<b>Application Ref:</b>	3/2026/0061	 Ribble Valley Borough Council <a href="http://www.ribblevalley.gov.uk">www.ribblevalley.gov.uk</a>
<b>Date Inspected:</b>	N/A	
<b>Officer:</b>	MC	
<b>DELEGATED ITEM FILE REPORT:</b>		<b>REFUSAL</b>

<b>Development Description:</b>	Lawful Development Certificate for existing use as Industrial/Commercial Landscaping Construction Business and associated activities (mixed Use Classes E(g), B2 and B8) including, a) the parking and unloading of plant and machinery and commercial vehicles, b) the storage of materials associated with landscape contracting, c) The storage and maintenance of vehicles, tools, equipment, and ancillary items, d) The administrative functions of the Business, and e) The siting of containers and other buildings/covered areas for general storage purposes. and engineering operations to form concrete and tarmac hardstanding areas across the site and an earth bund.
<b>Site Address/Location:</b>	Lane Ends Farm, Hothersall Lane, Hothersall, PR3 2XB

Drawing file: planx_downloads / 26_0061_3505_003A_Existing_Uses_2feb26.pdf

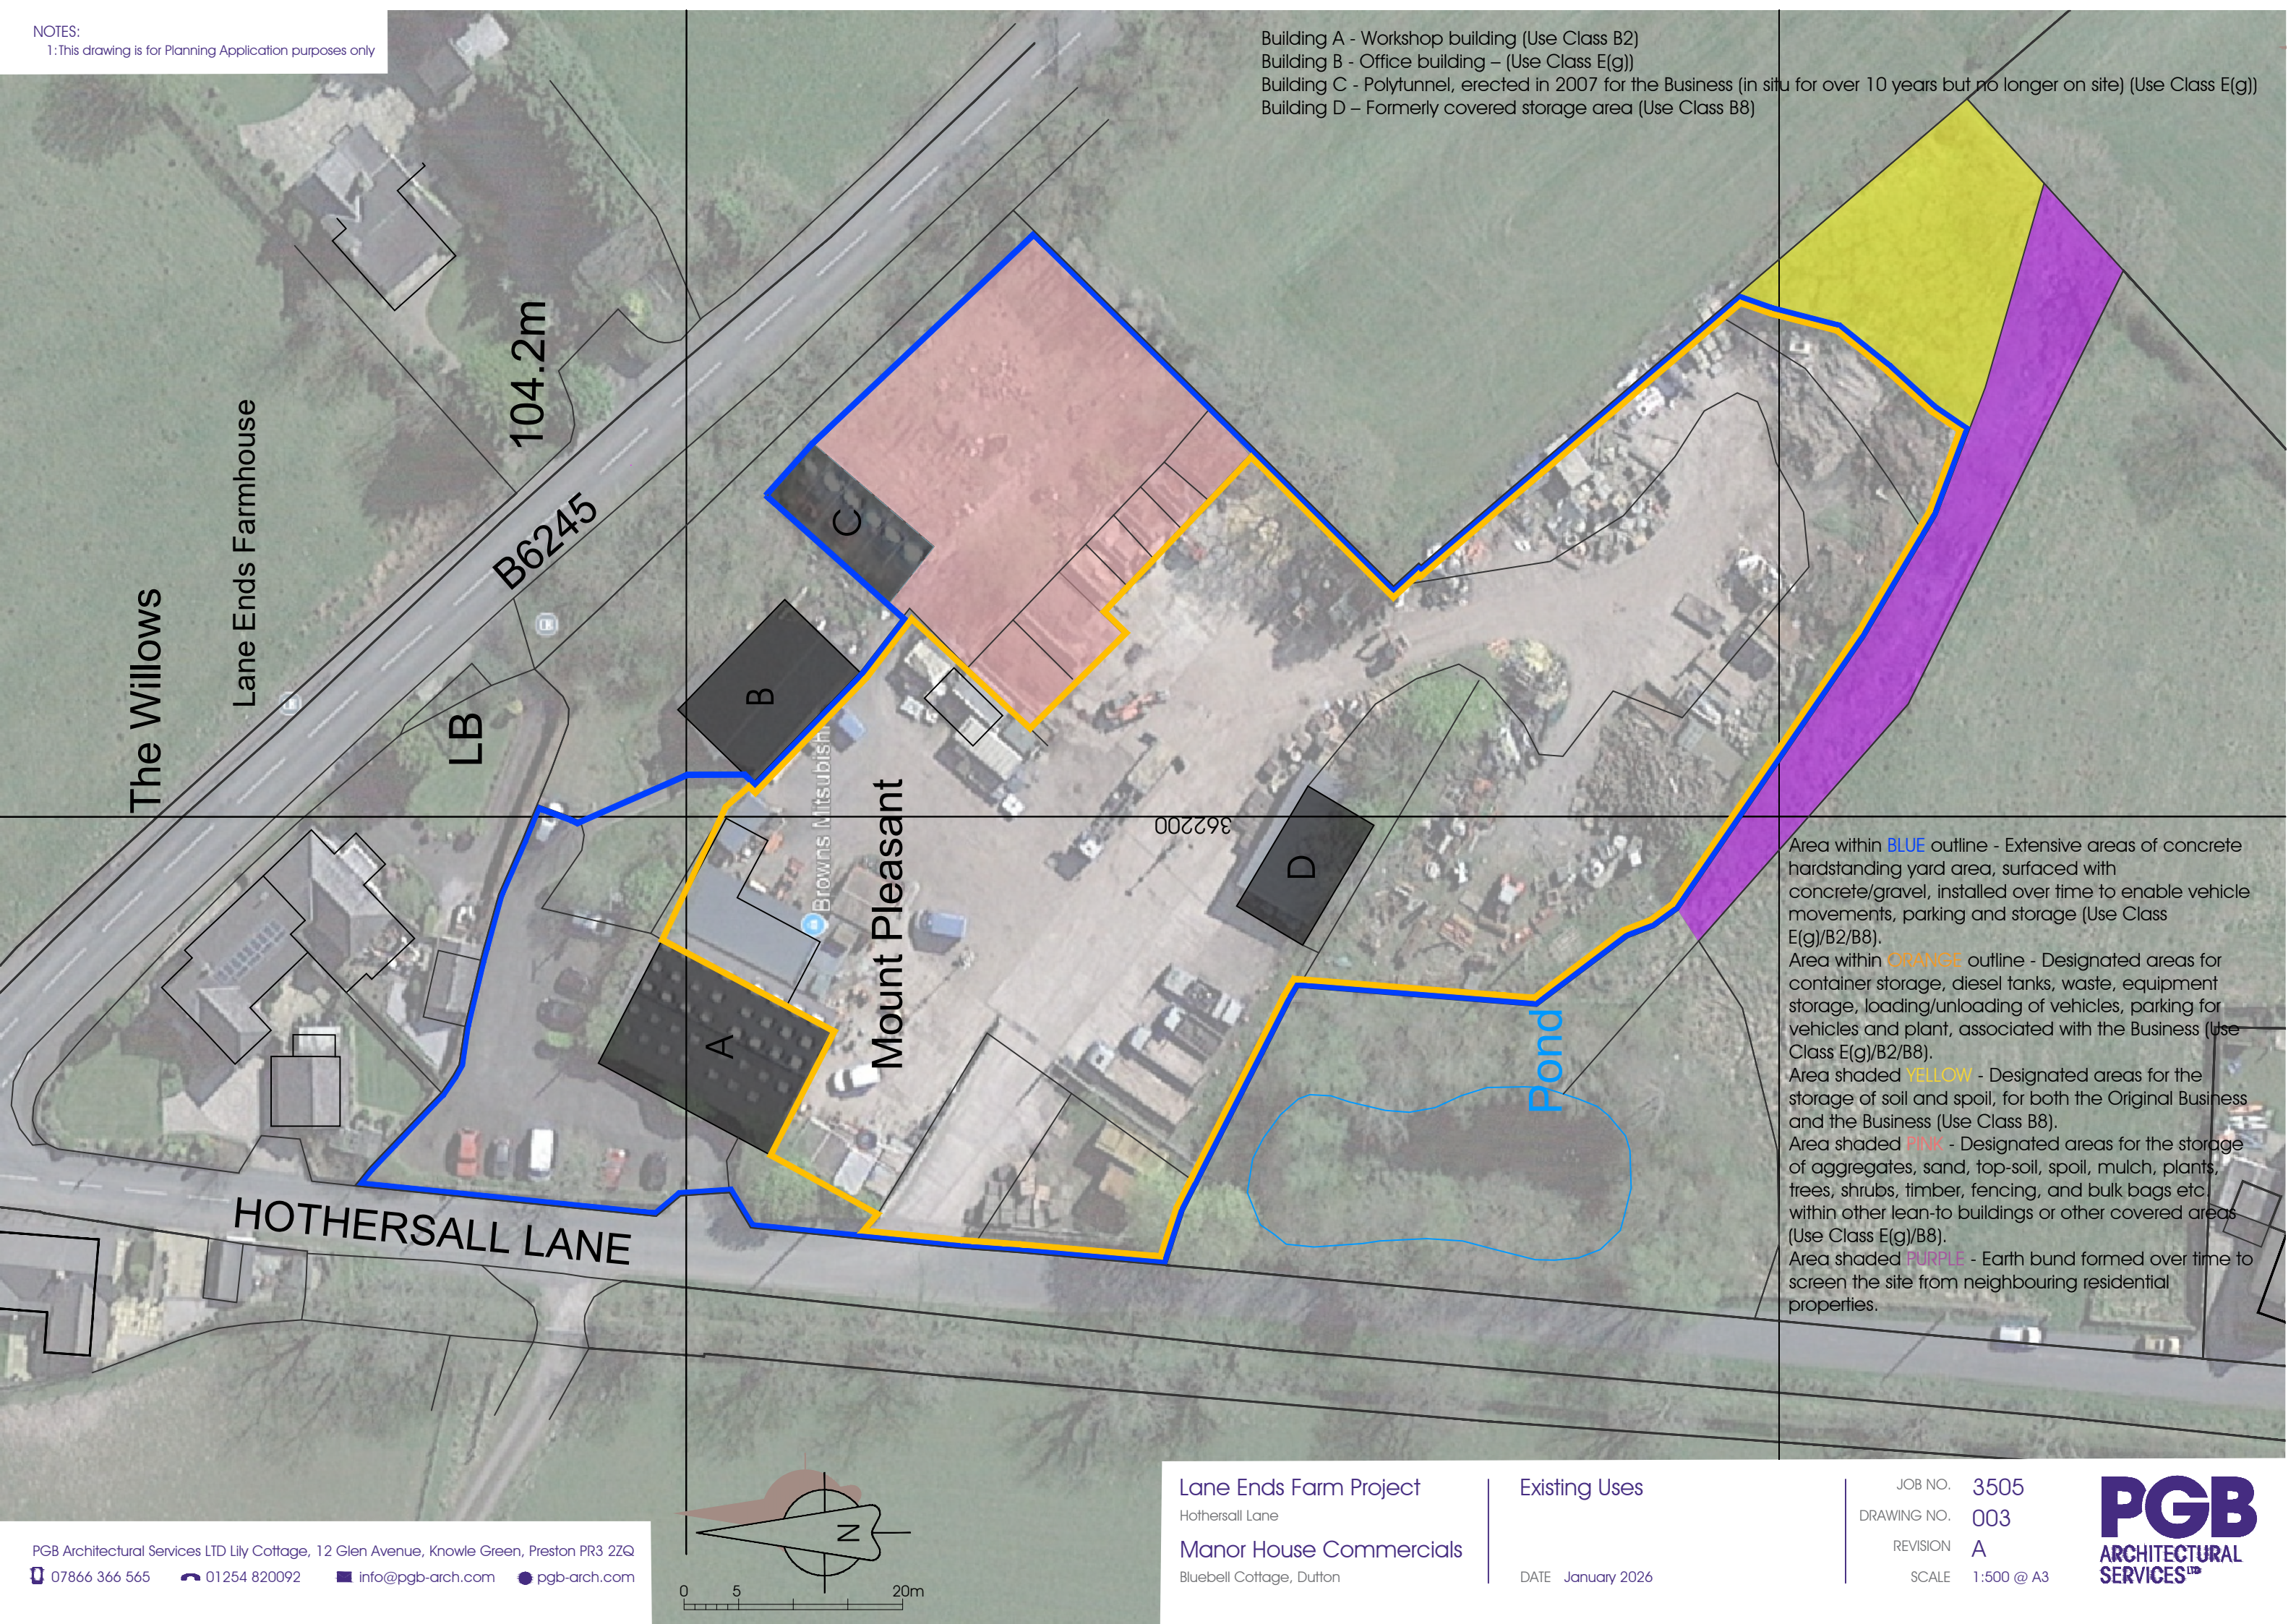
Firstly, with regards to the area outlined in orange on drawing ref: 003, the applicant considers that this area was used for the container storage, diesel tanks, waste, equipment storage, loading/unloading of vehicles, parking for vehicles and plant, associated with the Business (Use Class E(g)/B2/B8).

However, the Council's position is that the orange edged area includes land which formed part of the functional planning unit of the landscape business as such this land should be considered lawful B2 use with the exception of the existing access and the areas in front of the existing office and repair garage which now fall within the planning unit of the MOT testing centre (Sui Generis use).

As such, given that the land outlined in orange includes land used to facilitate the MOT testing centre, such as the access and parking/manoeuvring areas, it is not considered that the land edged in orange has been used solely for the suggested uses as Use Class E(g)/B2/B8 for a 10 year period, given that the most recent use of the site is currently operated as Sui Generis and any remaining land falls within the B2 use class .

Drawing ref: 003 states that the workshop building (Building A) is in B2 use class and the office (Building B) is use class E(g). It should be noted that these two buildings are included within the red edge for the certificate of lawfulness but are both considered to be in Sui Generis Use rather than Use Class B2 and Use Class E (g) because they fall within the approved MOT testing planning unit.

Turning to the area highlighted in pink on drawing ref: 003, firstly, it should be noted that Building 'C' which references a polytunnel is no longer on the site. Some of the separated storage areas are still visible on the site and appear to be being used to store highway equipment. The applicant claims that the lawful use of this part of the land is Use Class E(g)/B8 and has been used as a designated area for the storage of aggregates, sand, top-soil, spoil, mulch, plants, tree, shrubs, timber, fencing and bulk bags etc with other lean-to buildings or other covered areas and is confirmed within the statutory declarations. When viewing google satellite imagery, over a ten year period, this piece of land highlighted in pink appears to have been partially used for the purposes of storage, which could include plants, trees and shrubs as there are areas of the land which appear to be vegetated. However, these uses are considered to be ancillary uses to the main landscaping business and therefore fall within the main B2 use class, rather than a separate Eg or B8 use.

Drawing ref: 003 also shows an area of land shaded in yellow, which the applicant claims is a designated area for the storage of soil and spoil for both the original business and the current business (Use Class B8). The Council disagree that this part of the site formed part of the planning unit of the previous landscaping business use. Having reviewed the previous google satellite imagery there is no evidence that this land has been used as storage.

The submitted plan showing the existing uses of the site (including hardstanding and engineering operations) as outlined on drawing ref: 003 suggests that the area outlined in blue includes areas of hardstanding which is considered to be lawful.

Much of the area outlined in blue includes hardstanding which when compared to aerial photographs does show that historically, parts of the site have been hard surfaced. However, it is not considered that all of the land outlined in blue under drawing ref: 003 comprises hardstanding as suggested within the plan. For example, google satellite imagery clearly shows the area shaded in pink as vegetated with trees/shrubs in June 2023. In addition, there are elements of the site located centrally where 'Building D' is shown on drawing ref: 003, where trees/vegetation are clearly visible in June 2023 on satellite imagery.

As such, it is not considered that on the balance of probabilities, the hardstanding in the area outlined in blue is lawful for the purposes of this assessment.

Turning to the engineering operations in relation to the earth bund, the supporting statement indicates that this has been created over time to screen the site from nearby residential properties. The earth bund is identified as the land shaded purple on drawing ref: 003 and appears to extend to the south-eastern corner and curve back eastwards. However, having reviewed the latest satellite imagery and upon visiting the site for a recent pre-application enquiry, it is clear that the bund has been extended southwards since 2023 and in particular, the eastern corner between June to September 2025.
